From: Anita Gardner
Sent: 30 April 2019 15:50
To: Lynnyrd Wolfe
Subject: FW: R/72/19/PL - 2 New Dwellings - 6 Manor Road, Rustington
Attachments: 6manorproposedplans rev1.pdf; desacc6manor rev1.pdf; 6 manor street scenes for height.pdf; 6manorproposedsite rev1.pdf; 6manorproposedelevs rev1.pdf

I have started to receive representations on the above application. And it is evident that there are discrepancies in the plans submitted. Please can you let me have the following:

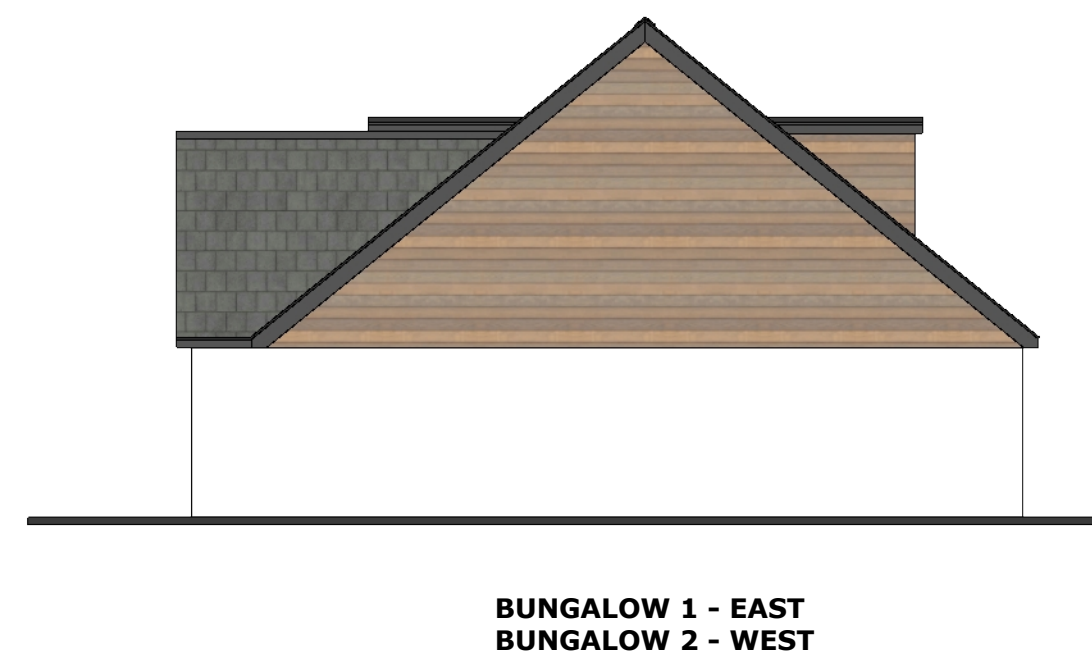
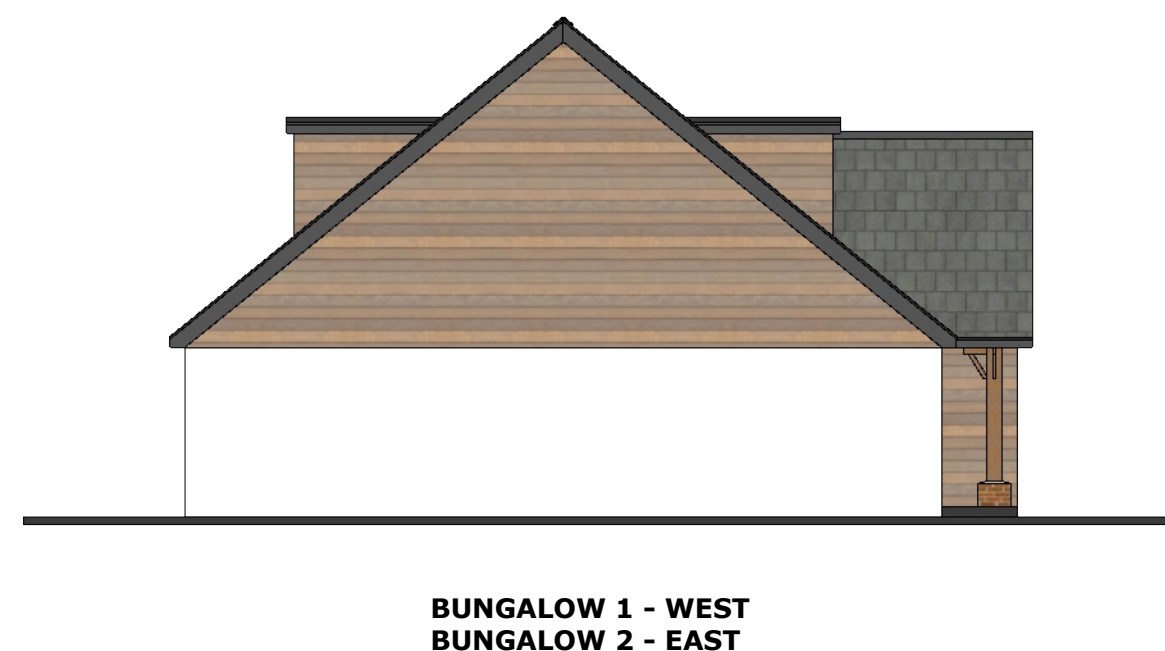
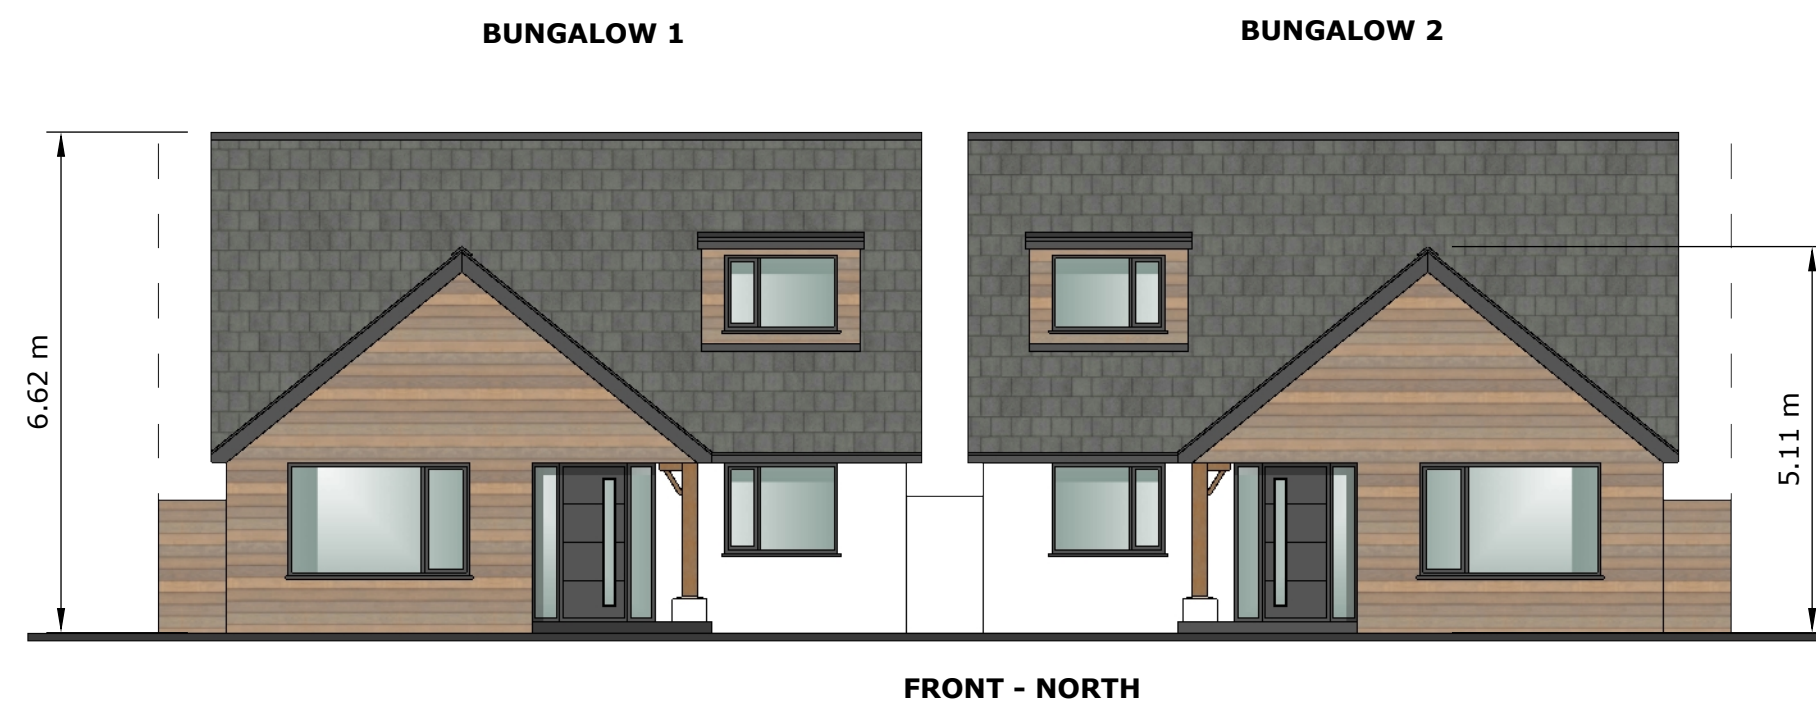
- The Ridge Height – the design statement states the ridge height will be 6.2m but the elevation drawing show a height of 6.62m and the elevations appear to scale the larger height, a difference of 0.42m.

- The roof plan on the site drawing does not show the front and back dormers but shows barn hips at opposite ends of each chalet bungalow, however the elevation drawing shows full height gable ends and no barn hips.

DRAWING: PROPOSED NEW DWELLINGS - PLANS **SCALE:** 1:50 @ A2 **DATE:** 29/03/2019 **DRAWING No:** DS/6MANOR/04

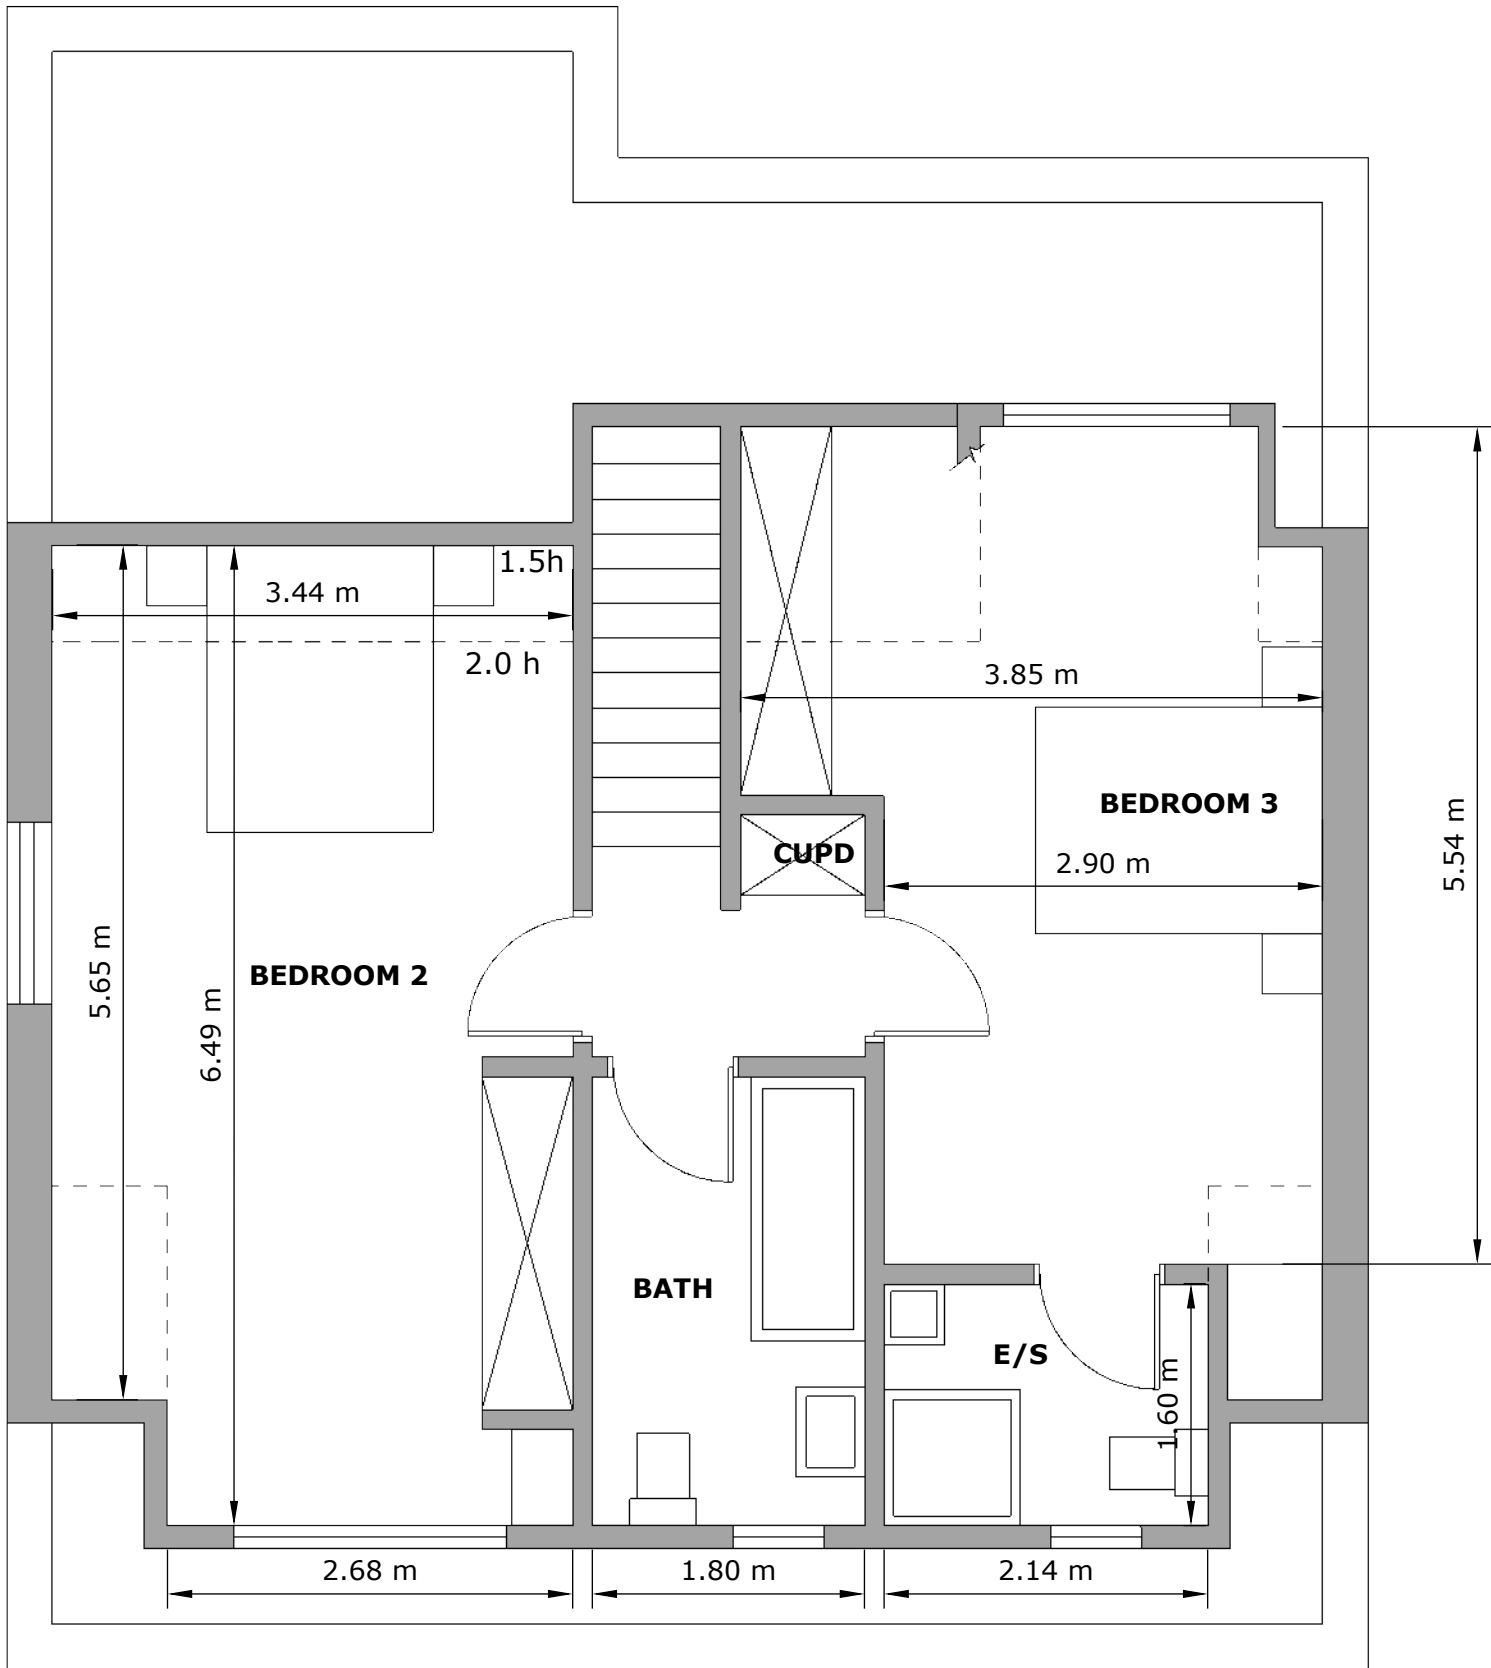
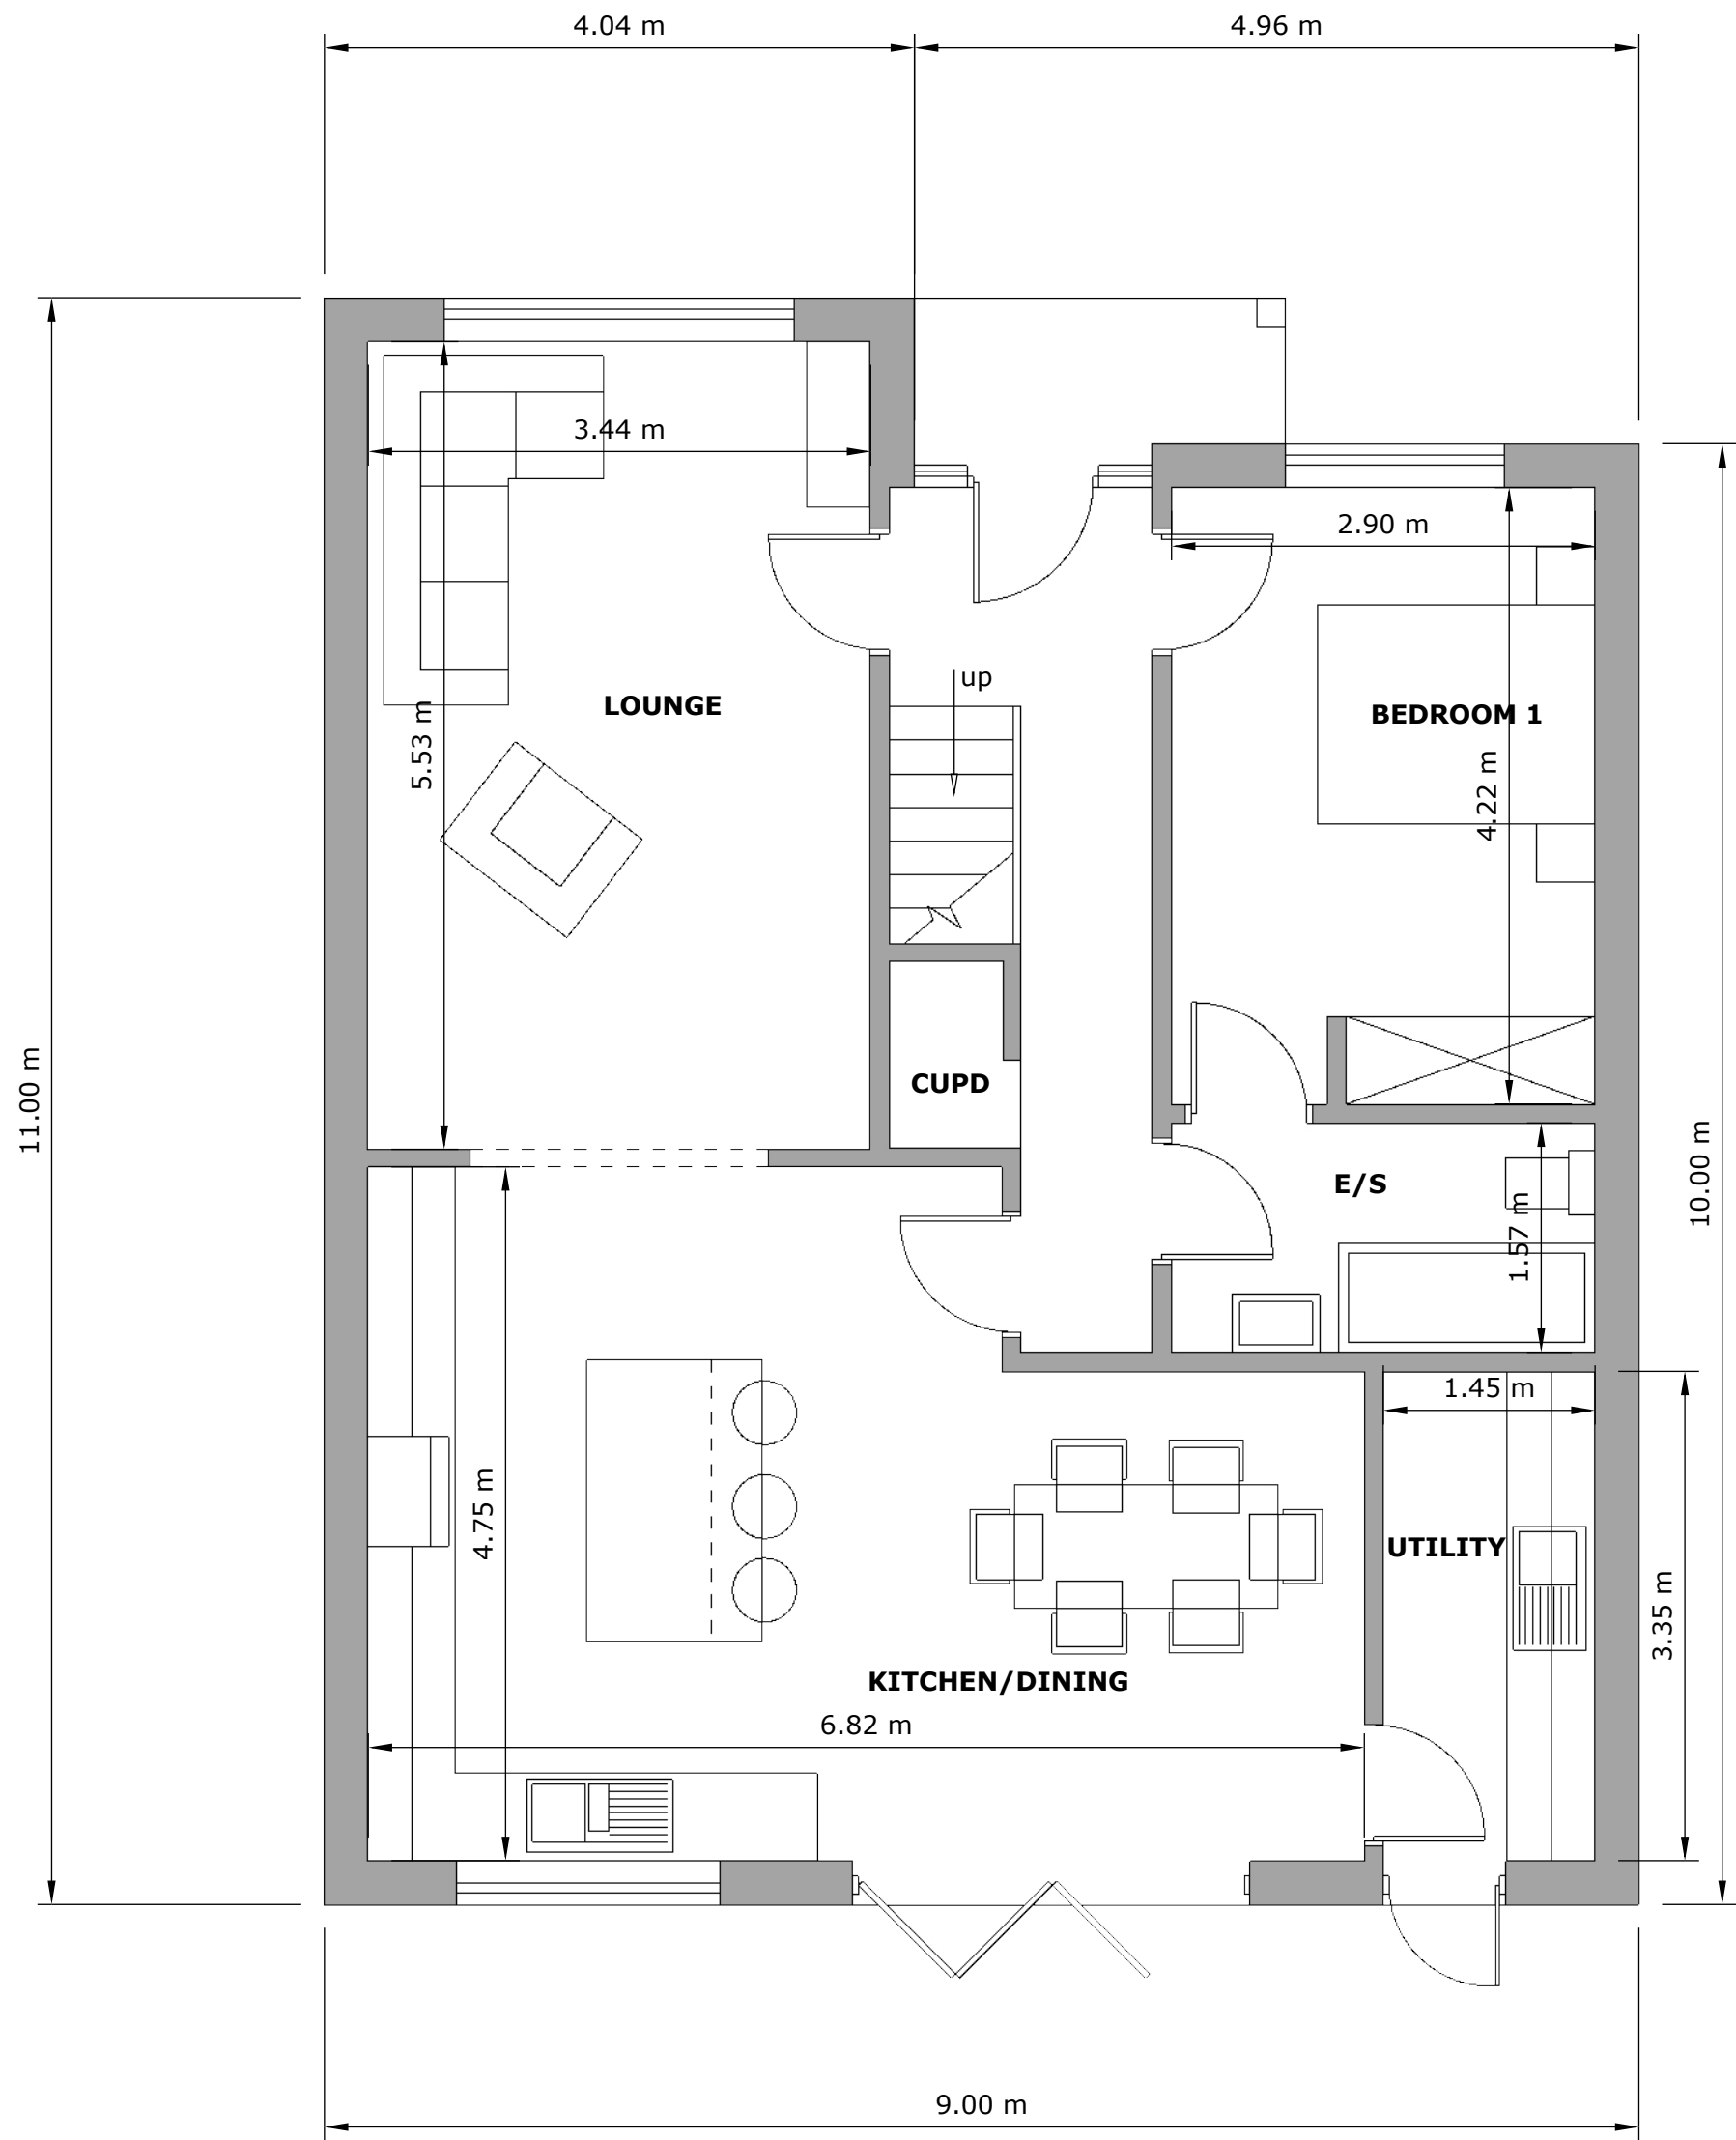
- The first floor plan shows a side window in Bedroom 2 which is not included in the elevations.
- The application forms state that there are no trees on the site but there are numerous trees of different size and species, mainly where the building plots are proposed, along with a very high hedge screening to the full width of the back boundary of the site. The forms are therefore incorrect and the trees should be indicated on the 1:200 block plan to show which are being removed and clarification given as to whether the rear hedging is being retained.
